15th March 2024

SAWBRIDGEWORTH EVANGELICAL CONGREGATIONAL CHURCH
Notes of Meeting with East Herts District Council and the Church to discuss
Heritage and Design Matters
11:00am on Friday 16th February 2024.

LONG SECTION THROUGH CHURCH A-A

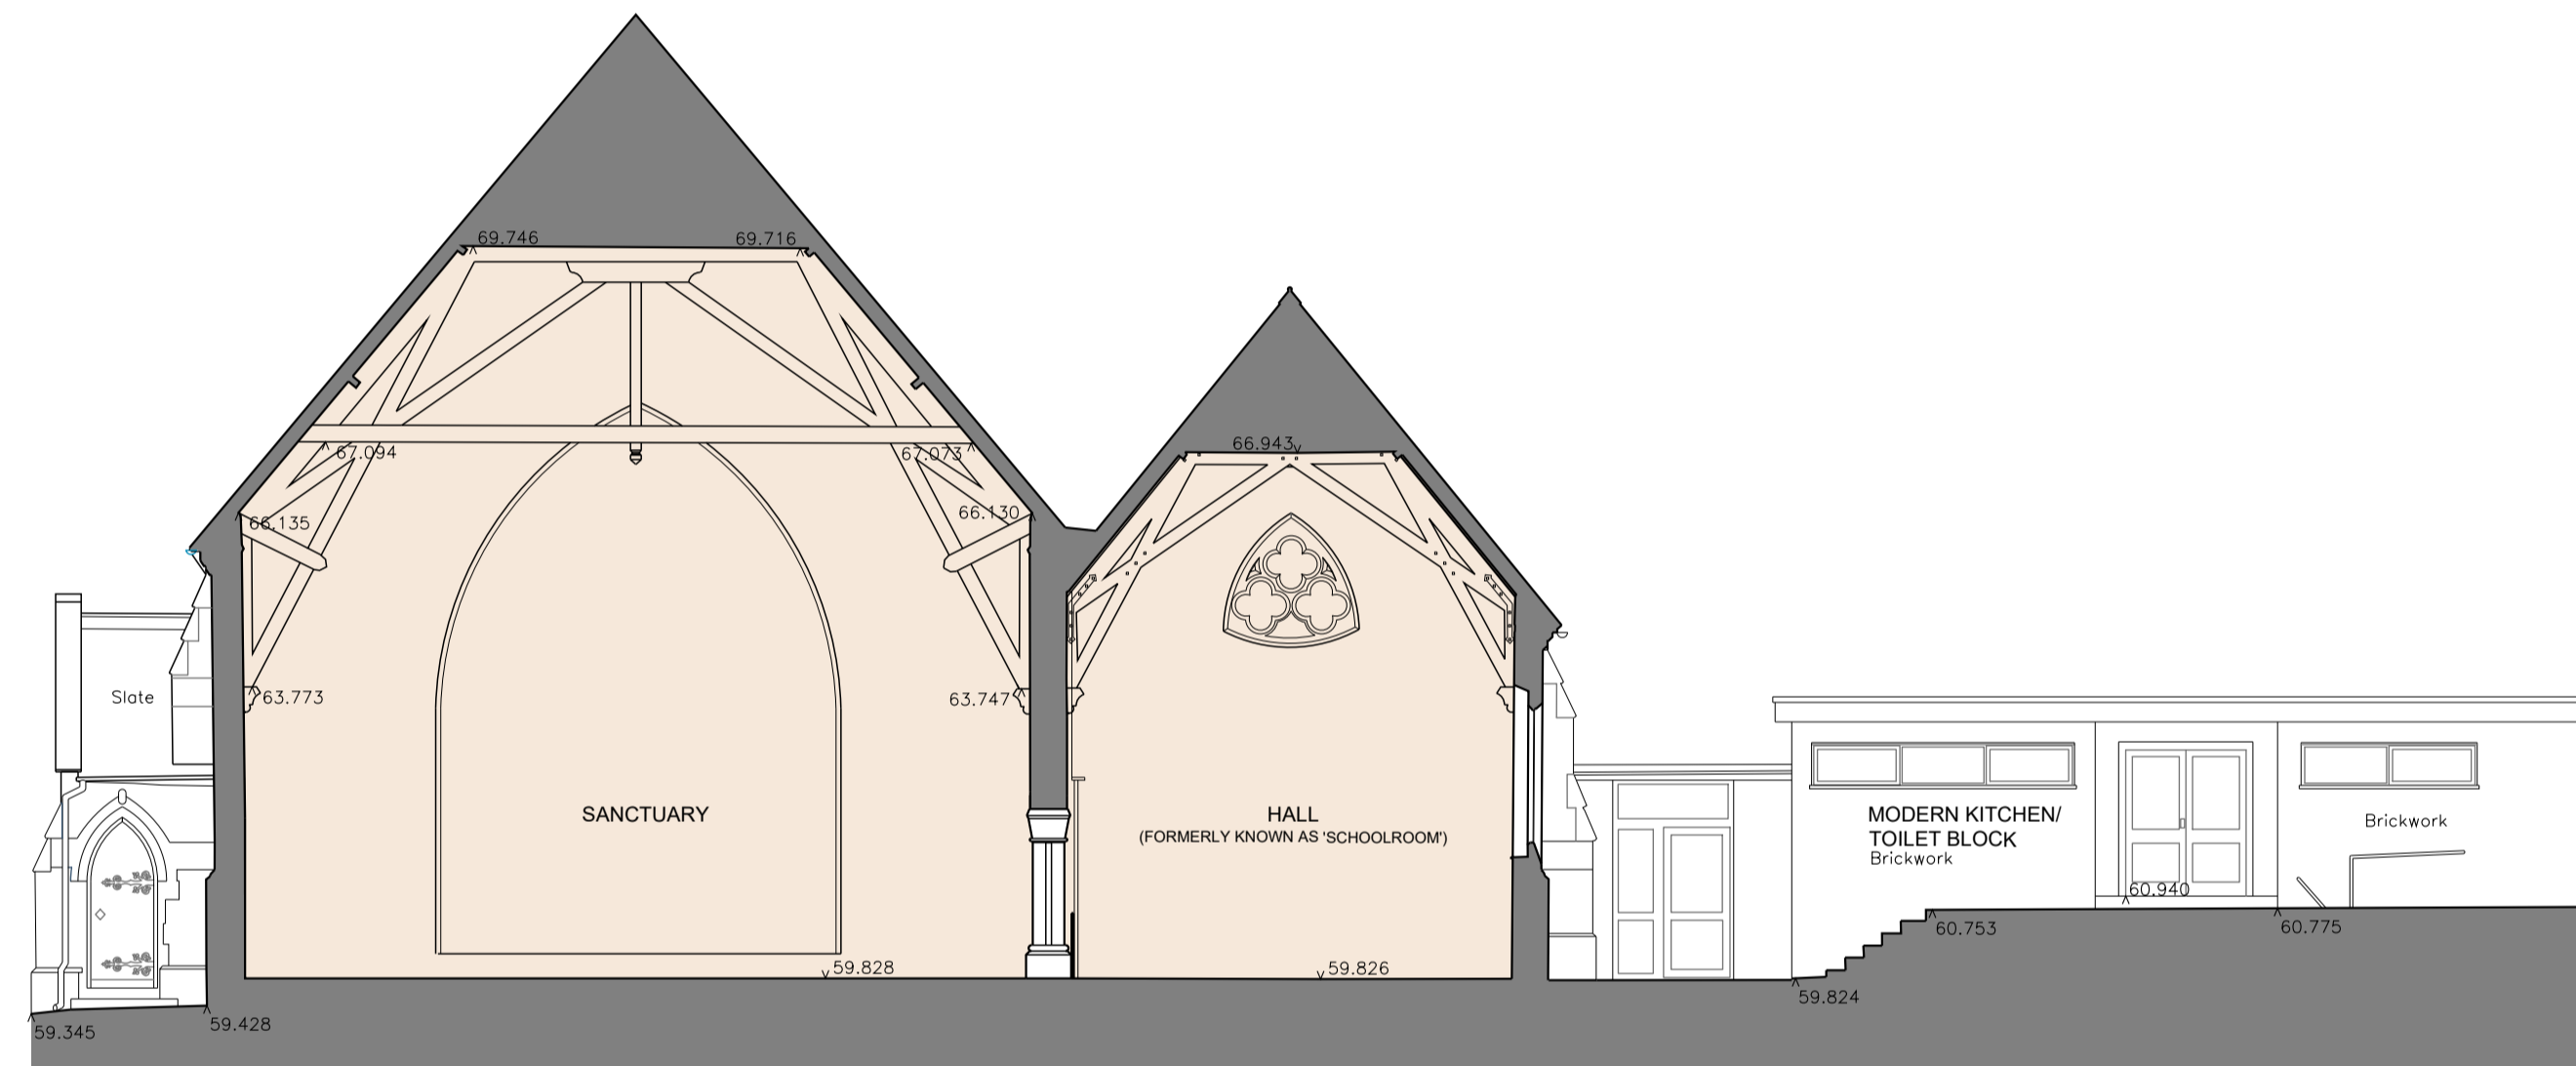
AS agreed that moving the console was beneficial to address access considerations in the designs, but asked whether the main organ pipes (not the lead pipes below stage) and housing could be retained in-situ, as a feature of the space, and the console retained such that the option remains to reconnect the console to the main body of the instrument in the future. AS could support the console not being located within the sanctuary space. It was agreed that CPL would explore this approach on the plans.

AS asked whether the pulpit could be retained and relocated elsewhere as a feature, preferably within the sanctuary, but alternatively with the adjoining school hall.

MK had some concerns over the practicality of moving such a heavy item, which may also be fixed to the dais. The detailed construction of the pulpit is not clearly understood at this point and is likely to be difficult to move in one piece. It may be possible to move to another location, but this may require some level of dismantling and rebuilding. CPL to investigate whether there is space to locate the pulpit in the organ alcove in addition to the organ itself.

1911 Classroom Block - North Elevation to Sub-Station

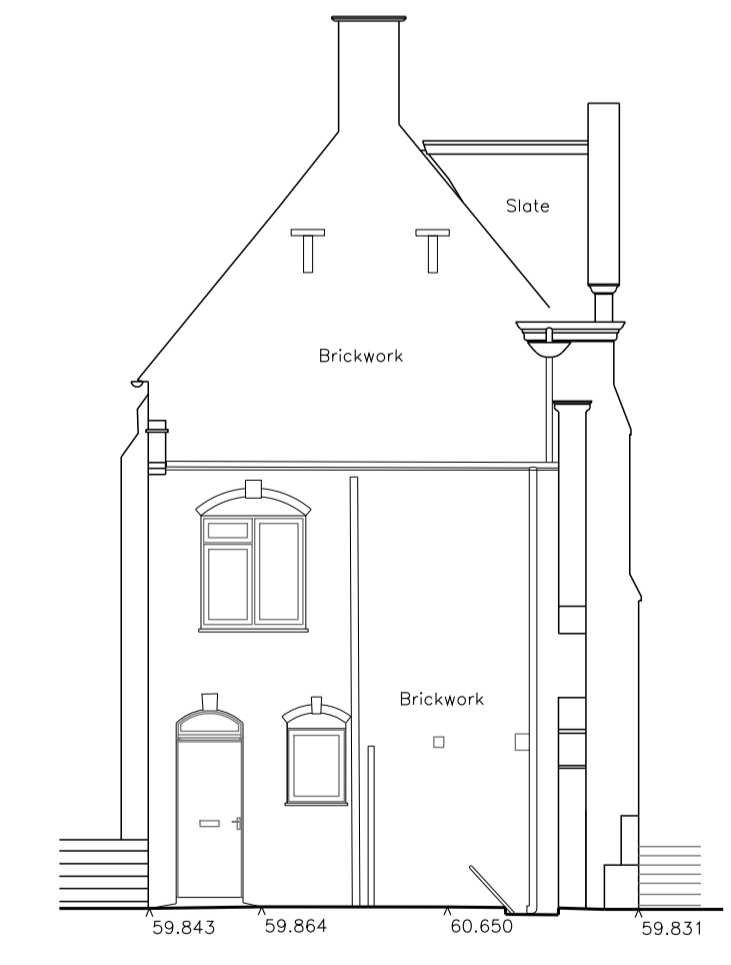
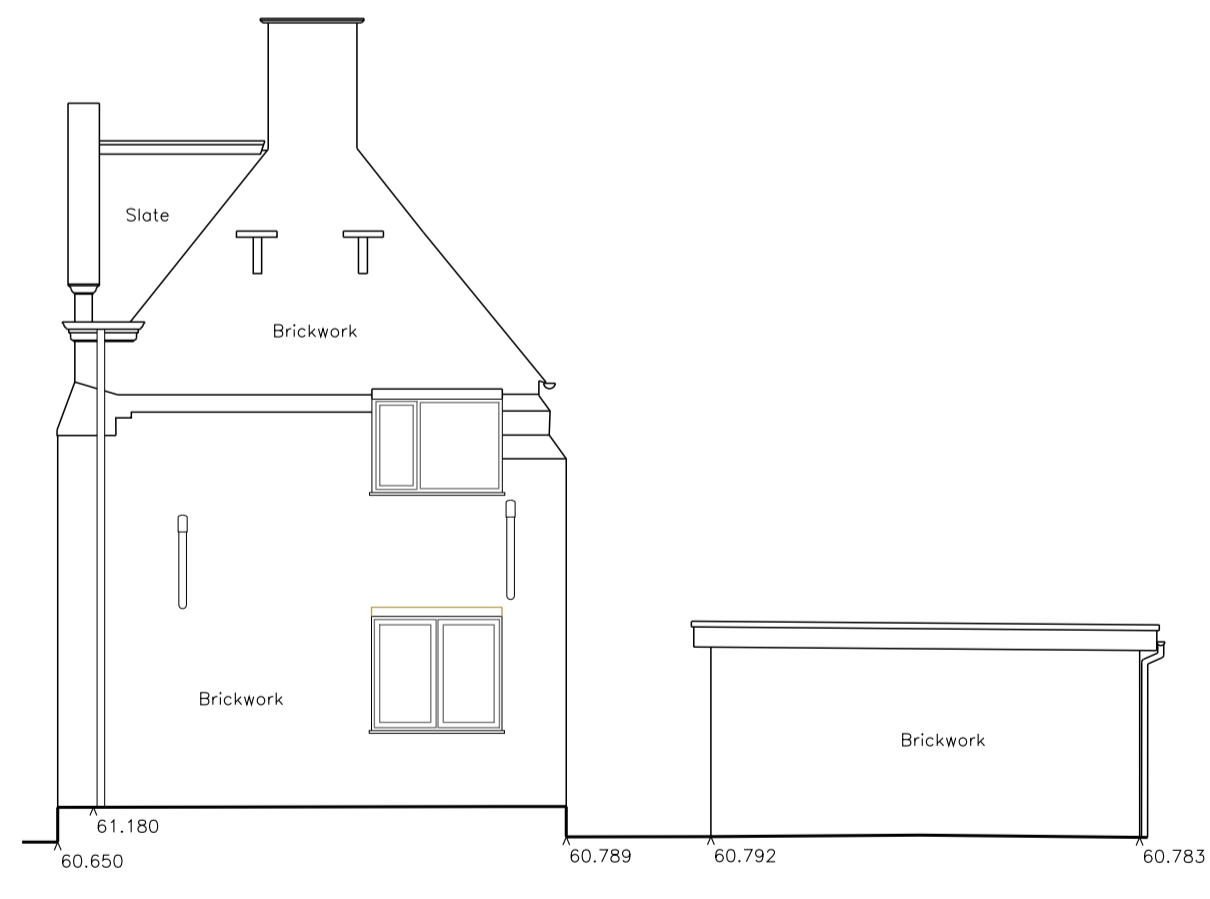
DA had previously circulated two alternative design approaches. One features 3 'punched' openings and the other one opening subdivided into four elements, each separated by a stone mullion.

SFL felt that both approaches could be supported but slightly favoured the design with 4 elements, noting this made contemporary reference to the large church gable window, which is also subdivided into 4 elements. SFL commented that the design worked well but asked whether the coping would benefit from being more substantial in height. CPL agreed to explore this detail further.
